Your Ref TR010027

Monday 24 June 2019

**Application for a Development Consent Order for the M42 Junction 6 Improvement
Waterway: Grand Union Canal**

Deadline 2 Response to Examiner's Question

Drawing Title  
**FIGURE 8.3 PROPOSED LANDSCAPE PLANTING SHEET 1 OF 3**

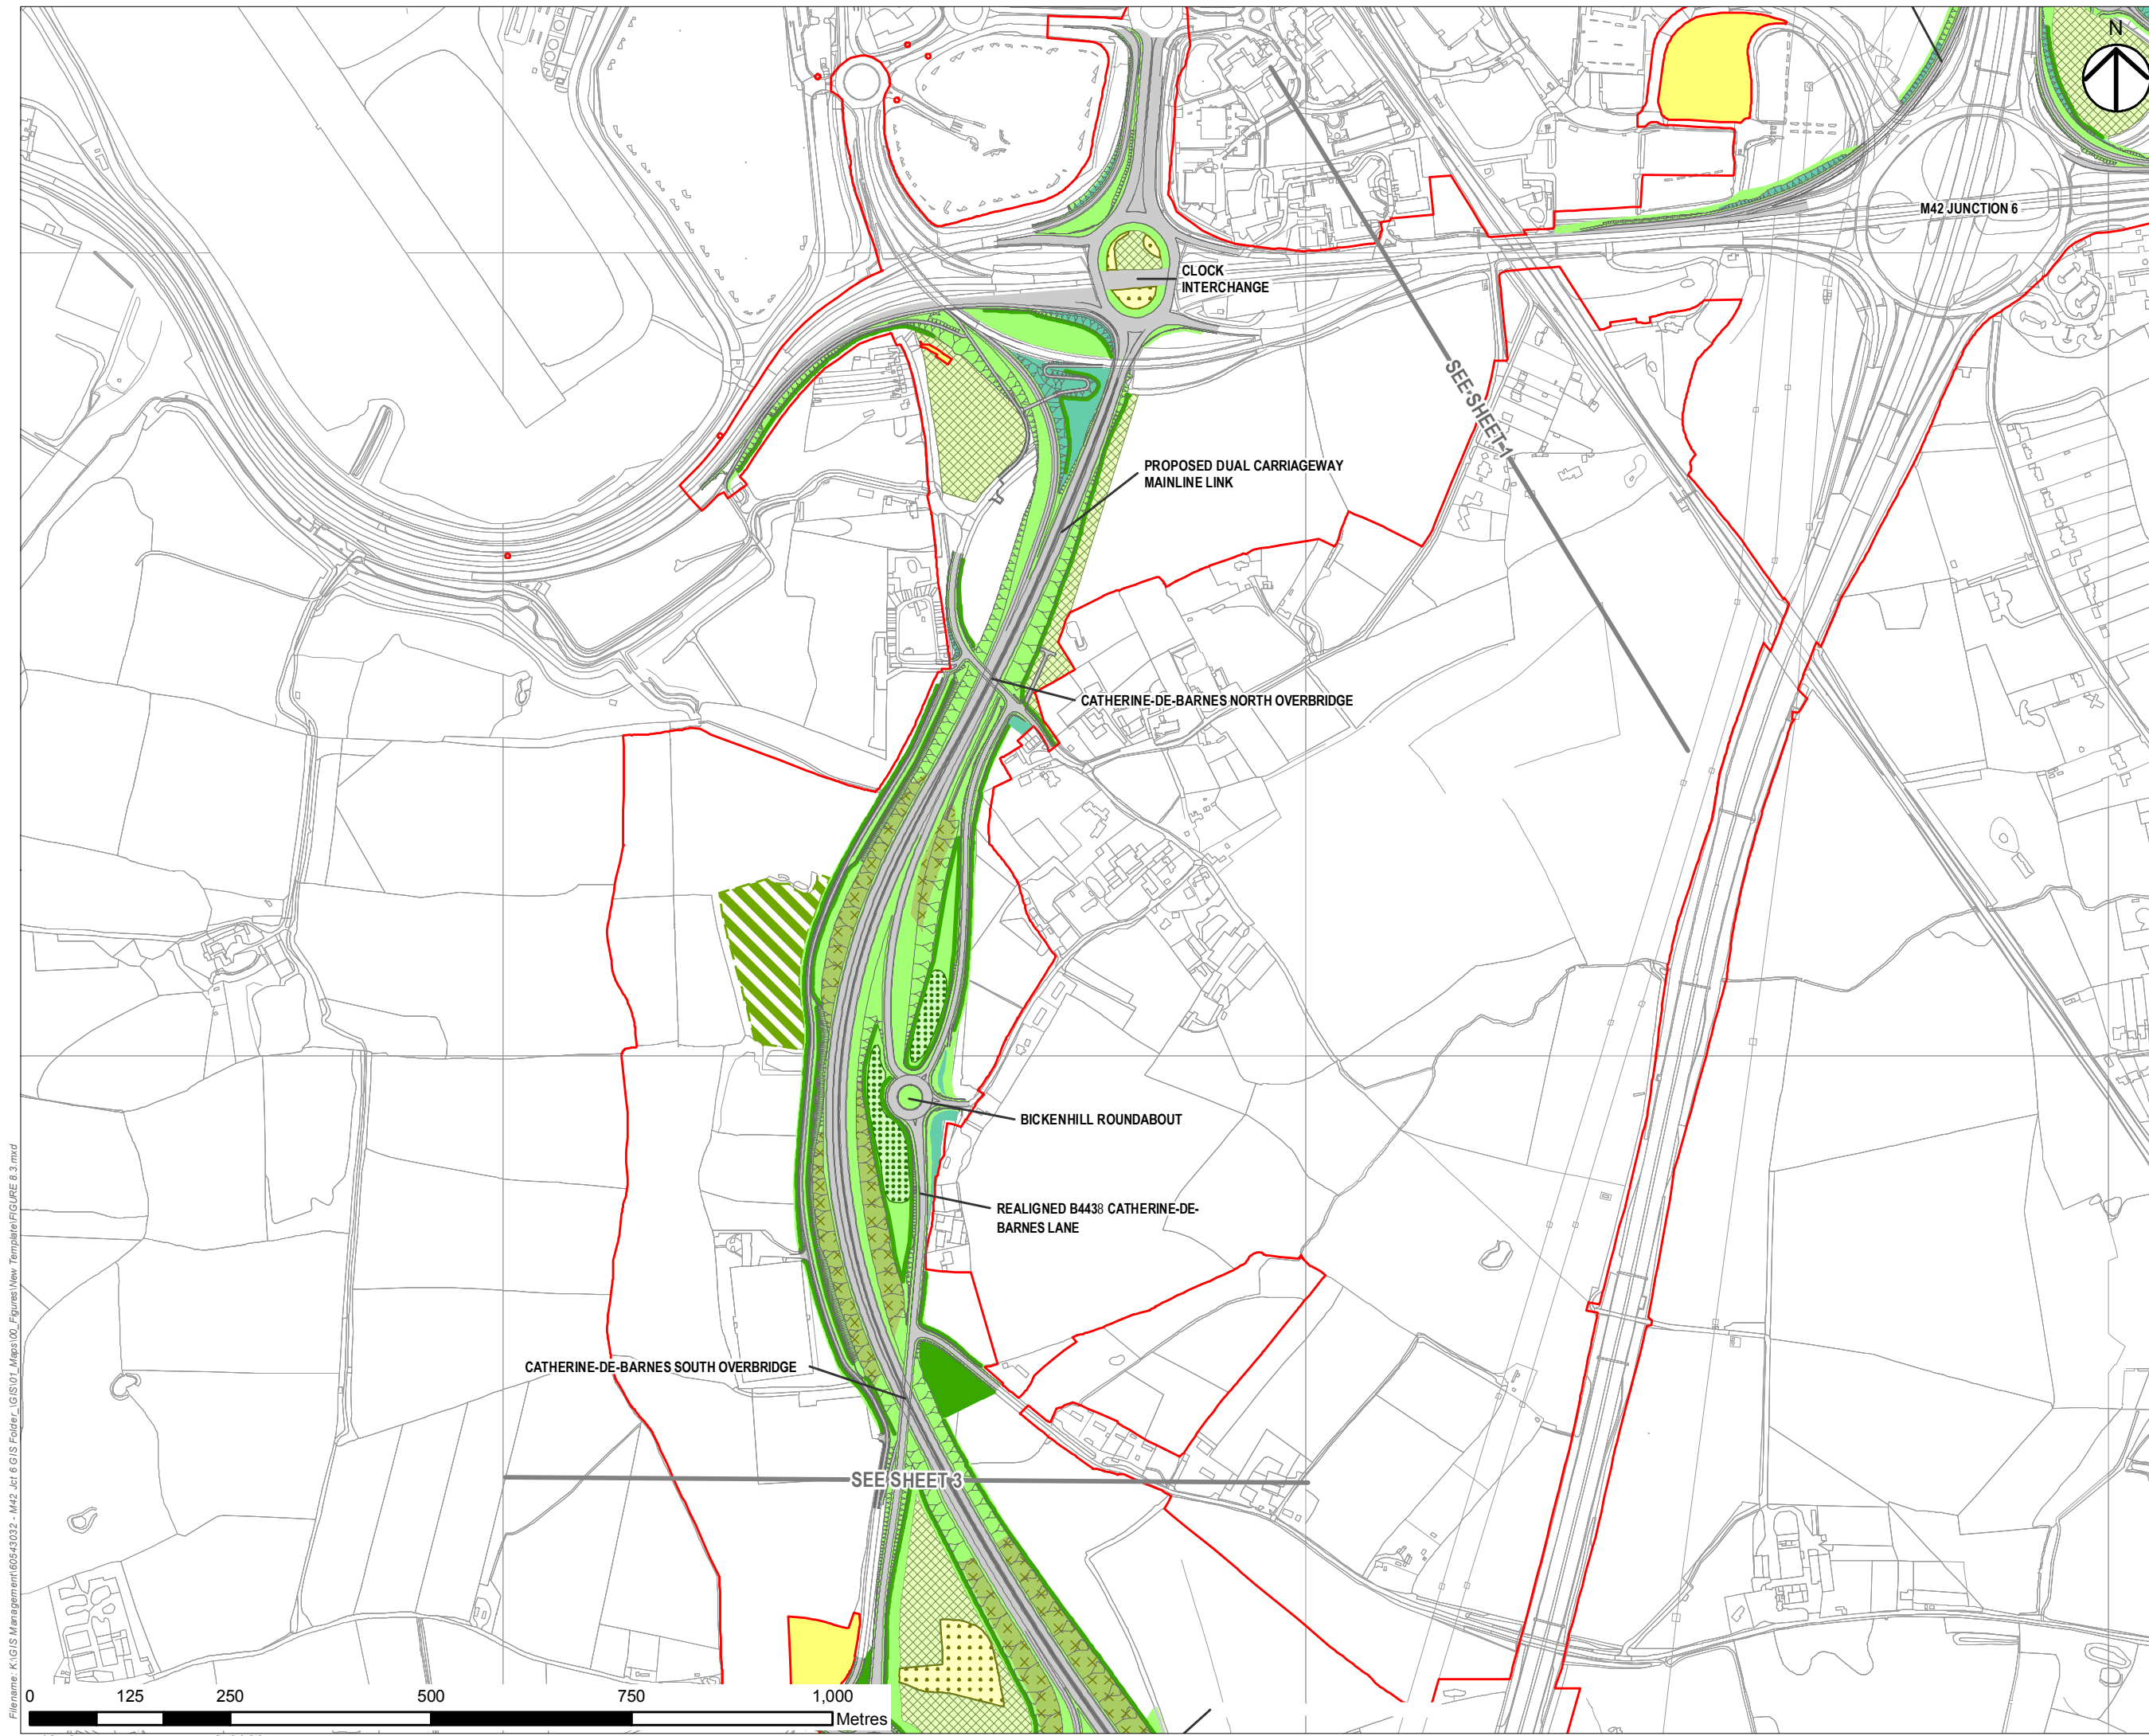
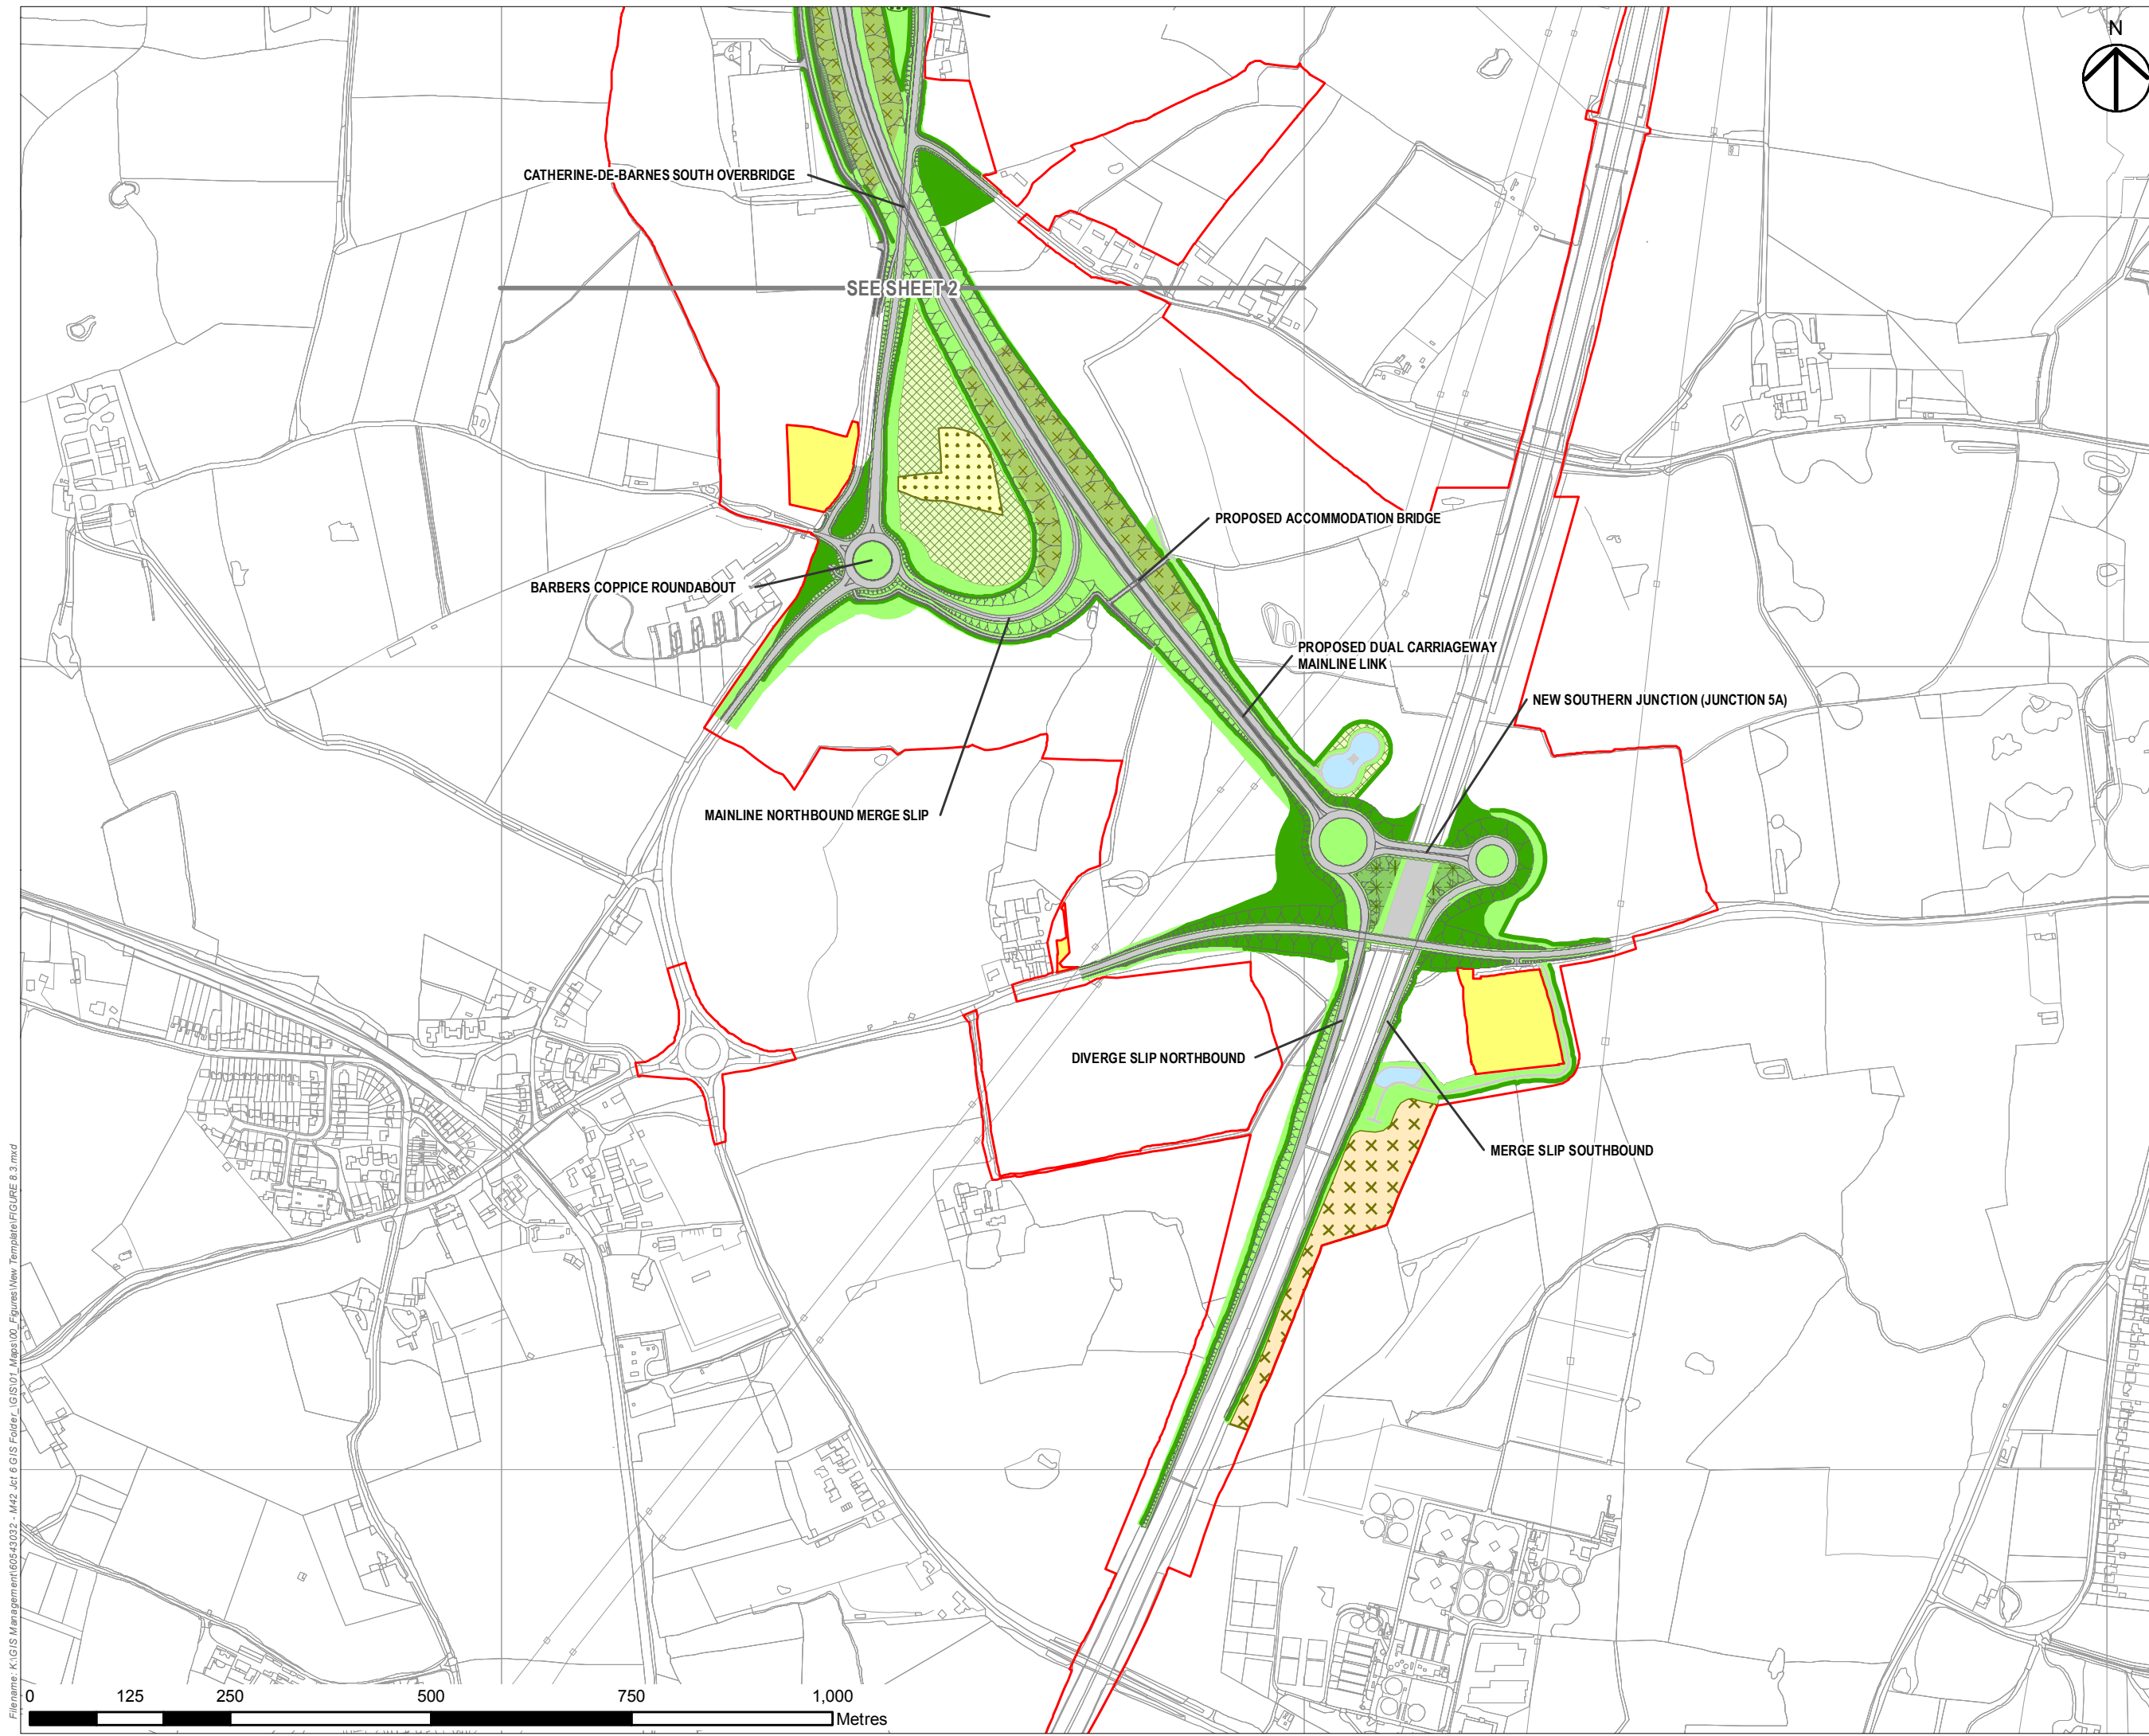
It is noted that the submission includes proposed landscaping adjacent to the junction works. We therefore consider that this natural screening is of importance to protect the views from the canal corridor and ask that these be required as early on as possible in order that they grow to provide an appropriate level of screening as soon as possible, for both visual and noise protection, to minimise the visual impacts of the proposal on canal users."
